BUILDING CODE OF AUSTRALIA REPORT

Prince of Wales Comprehensive Cancer and Blood Disorder Centre

STAGE 1 - SCHEME DESIGN

Dated: 9 March 2012

1 PLAN
LEVEL 1 STAGE 1 1:500

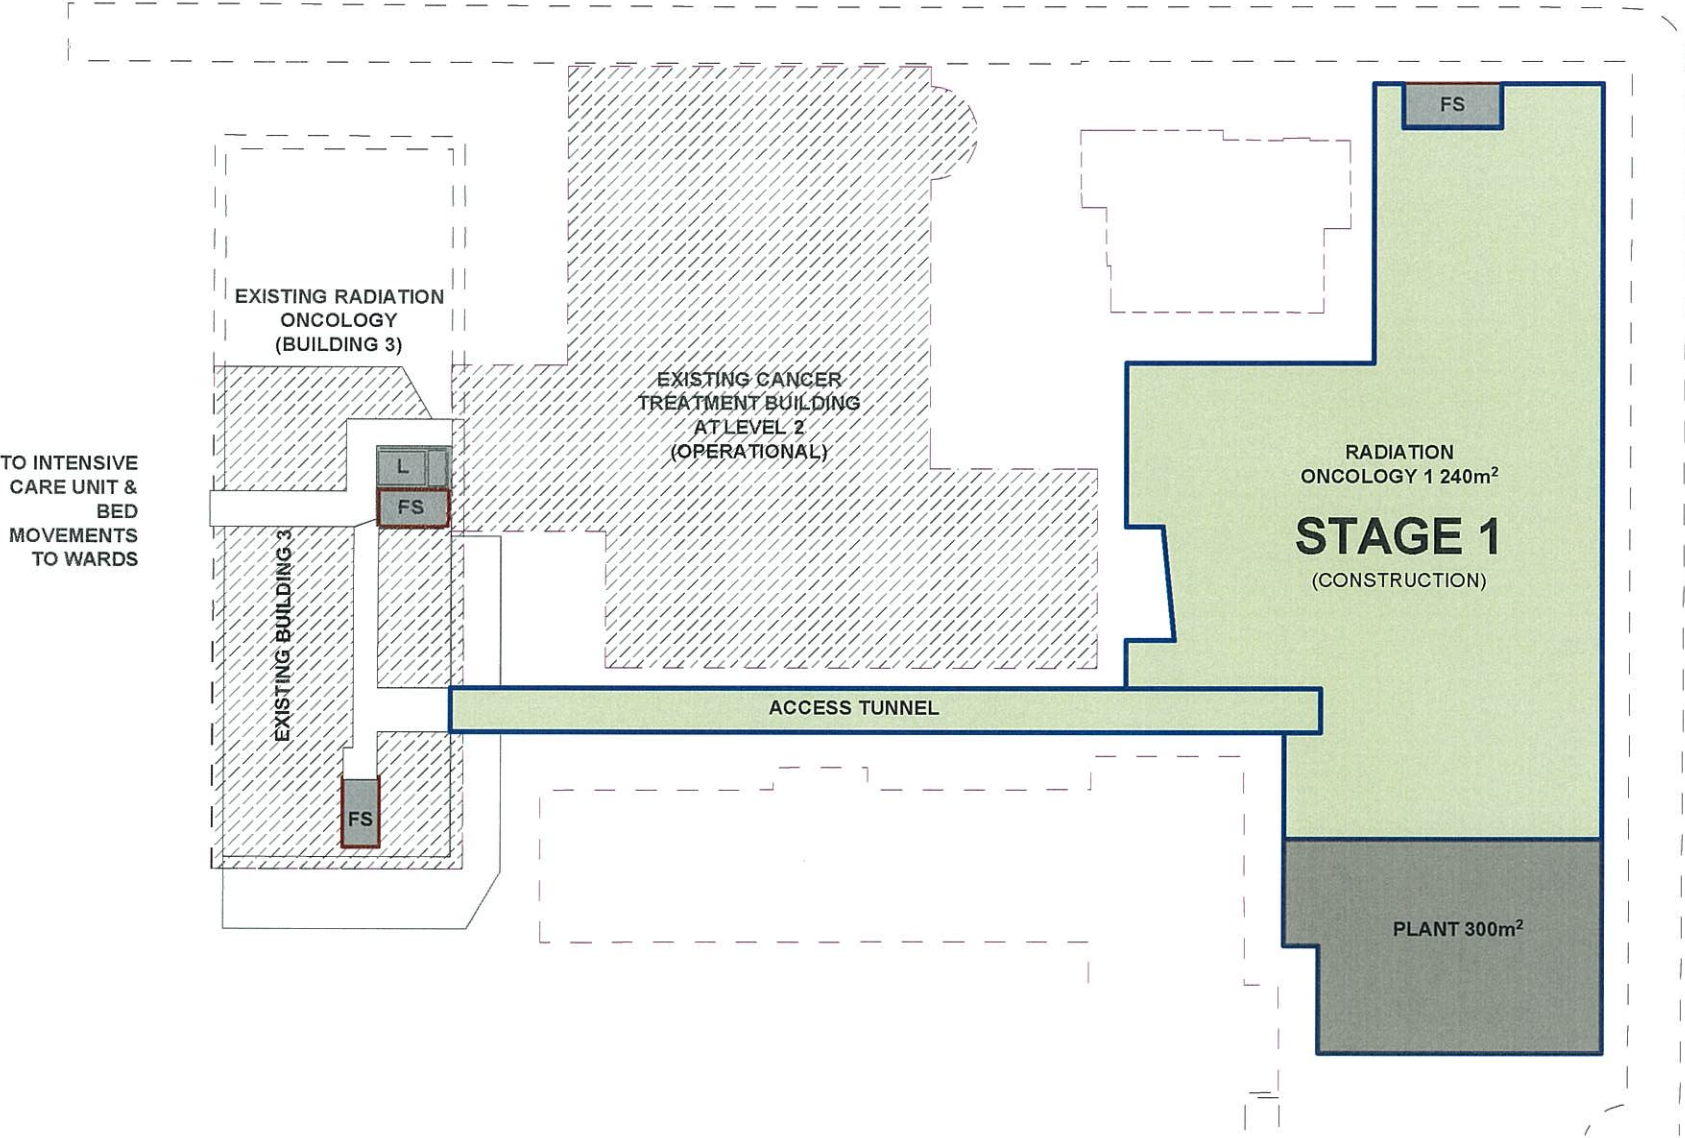
Assessment of architectural drawings indicates the following extended travel distances:

- Travel distance from the bunkers to point of choice exceeds 20.0m (i.e. measured up to 22.0m);
- Travel distance from the plant room, making allowance for plant room fitout exceeds 20.0m (i.e. measured approx. 30.0);
- Travel distance to required exits exceeds 40.0m (i.e. measured 45.0m)

The extended travel distances will be assessed as alternative solution by the fire engineer to achieve compliance with the performance requirements of the BCA.
